Rezoning Transportation Analysis

Petition Number: 2023-034

From: Jake Carpenter, PE

Revision Log:

SCHEMATIC SITE PLAN

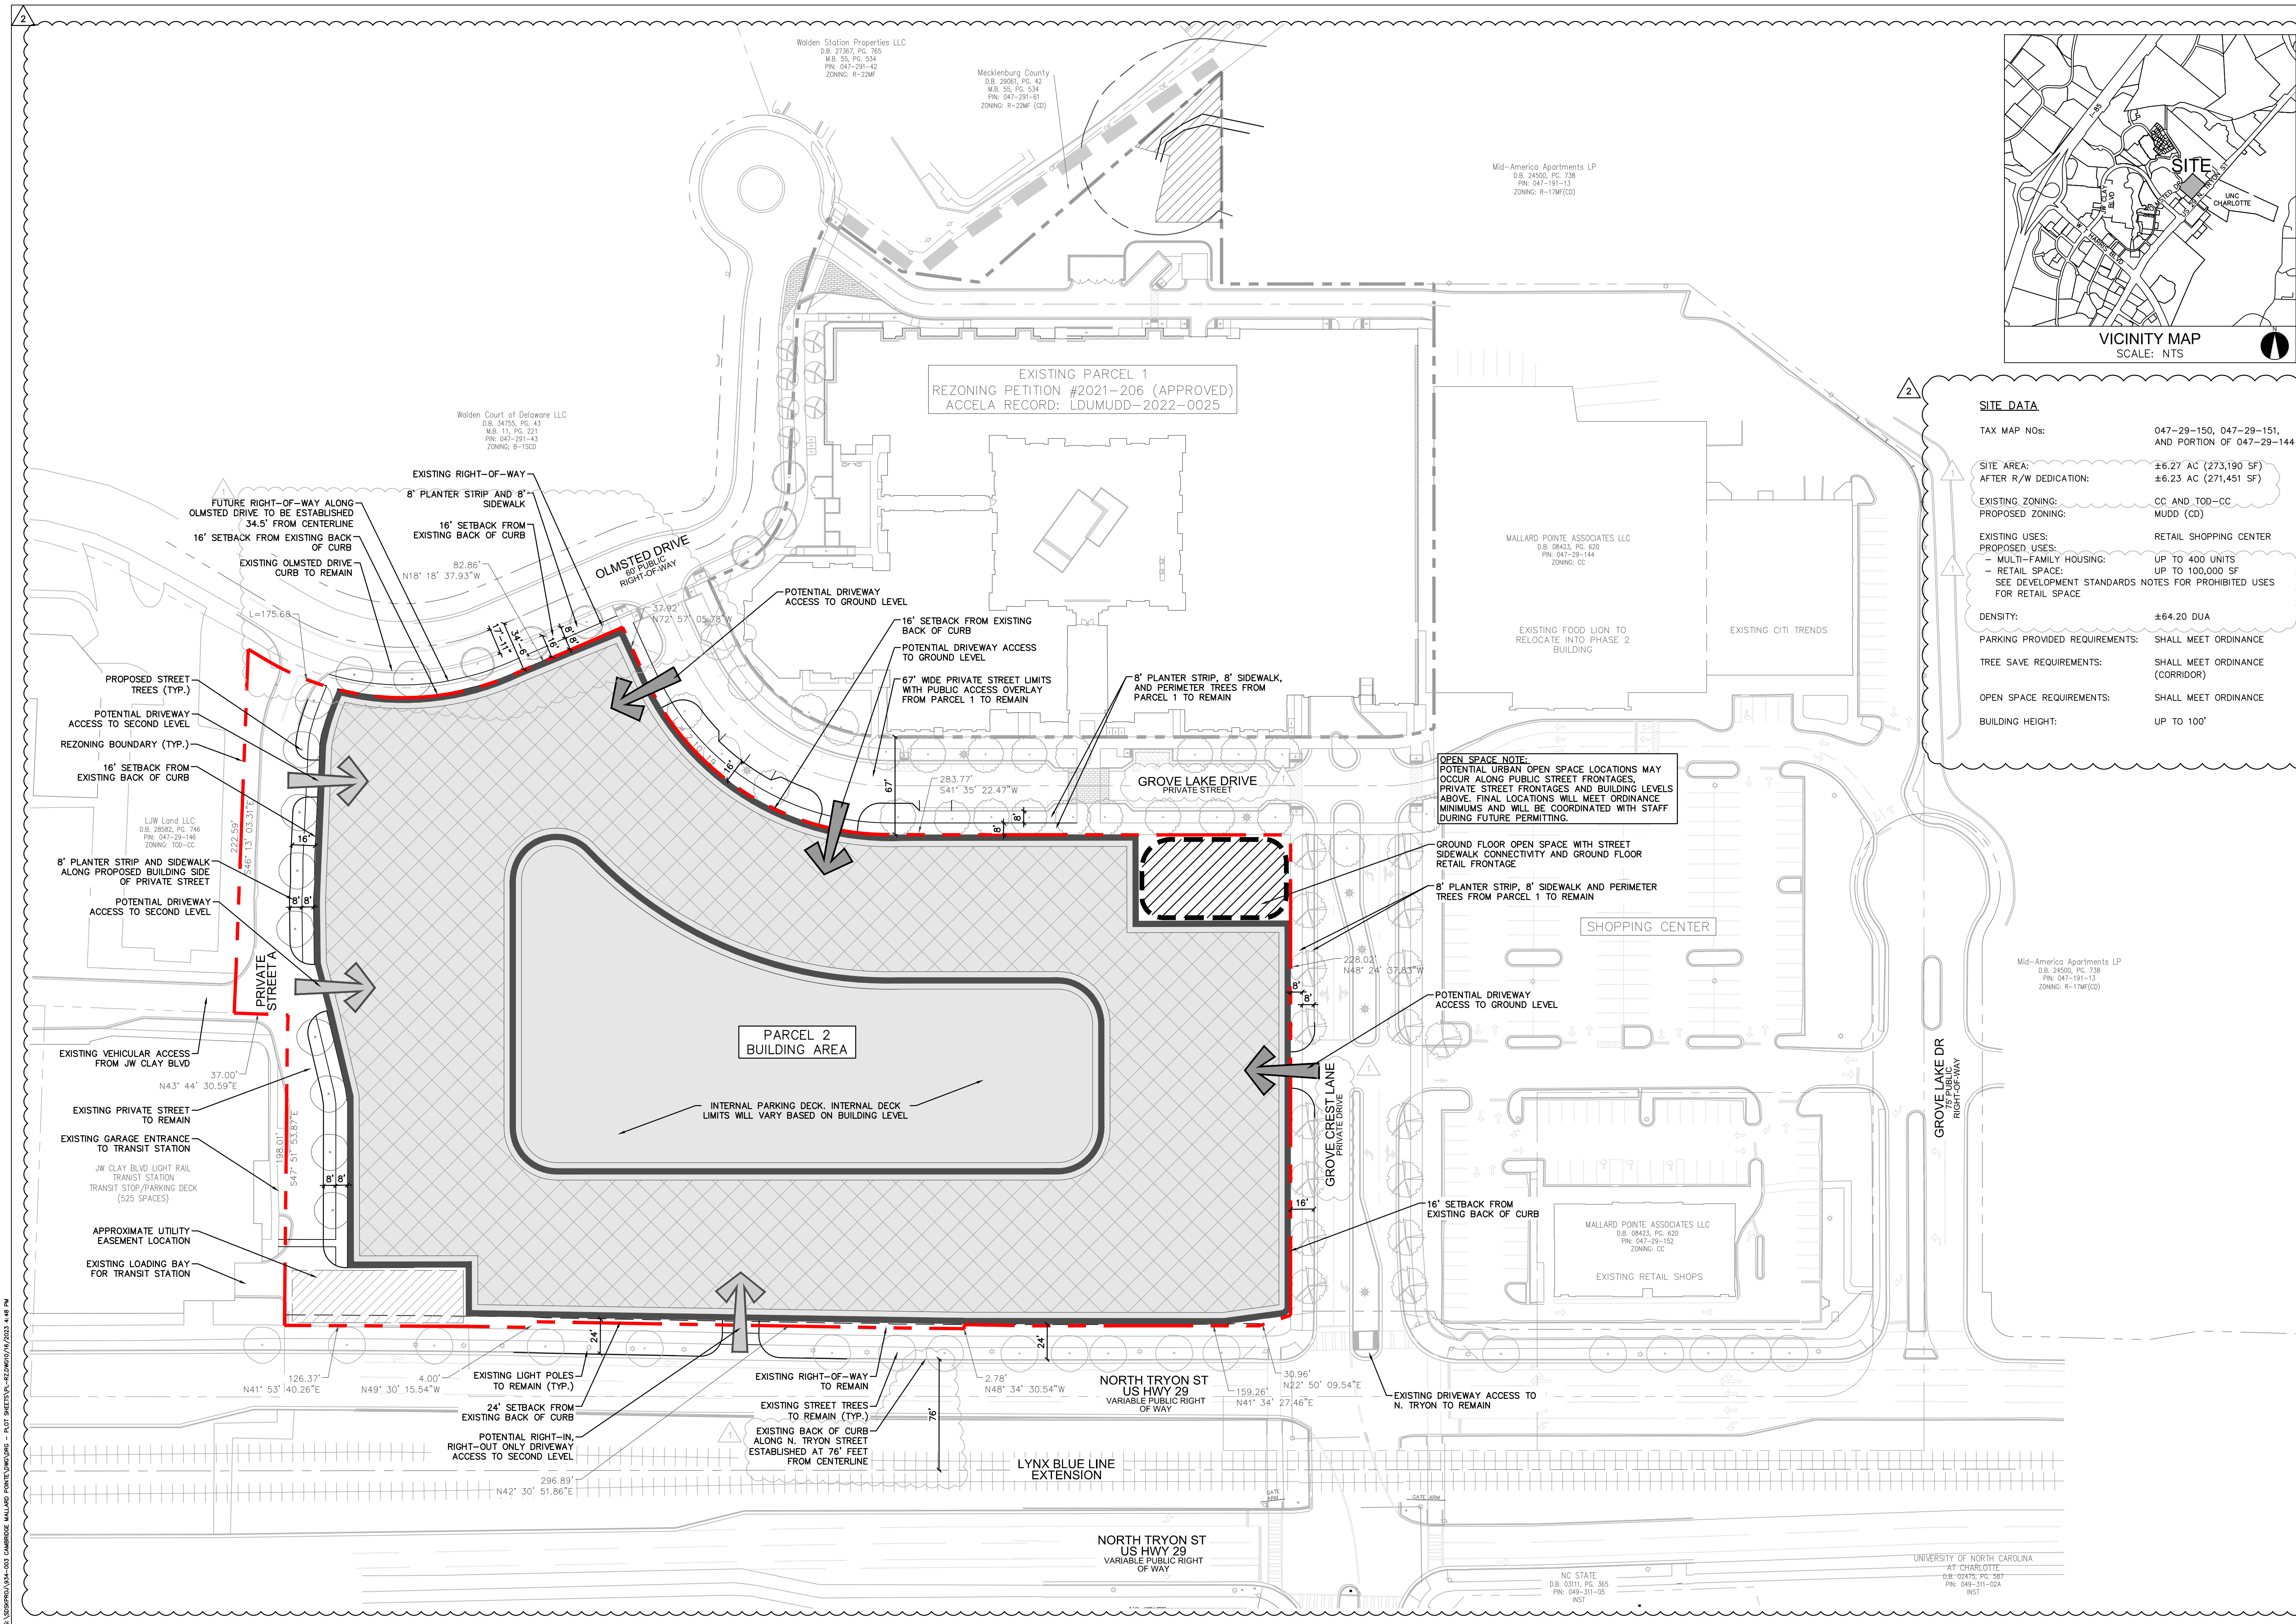
1. ~~Curbline:~~

a. ~~Tryon Street:~~ The future location of curb and gutter is in its existing location.

b. ~~Olmsted Drive:~~ The future location of curb and gutter is in its existing location.

Label and dimension the curb and gutter from the centerline for each road on the site plan.

3. ~~NEW COMMENT FROM 10-26-23:~~ Remove Access point that was added to Tryon Street.

4. ~~Revise site plan and conditional note(s) to commit to dedicate a minimum of 34.5 feet of right-of-way from the road centerline of Olmsted Drive. The site plan shall label and dimension the right-of-way from the road centerline.~~
5. ~~Revise site plan and conditional note(s) to commit to construct an 8-foot planting strip, and 8-foot sidewalk on Olmsted Drive per Chapter 19. The site plan shall label and dimension both items from the back of curb and gutter or edge of pavement.~~
6. ~~The proposed dwelling units exceeds 12 per acre. Per Chapter 20 Subdivision ordinance, revise site plan and conditional note(s) to commit to construct an 8-foot planting strip, and 8-foot sidewalk along Olmsted Drive. The wider sidewalk also meets the Charlotte WALKS Policy.~~

8. ~~Request: Revise site plan and conditional note(s) to commit to extending the 8-foot sidewalk on Olmsted Drive to J W Clay Boulevard CIP project.~~
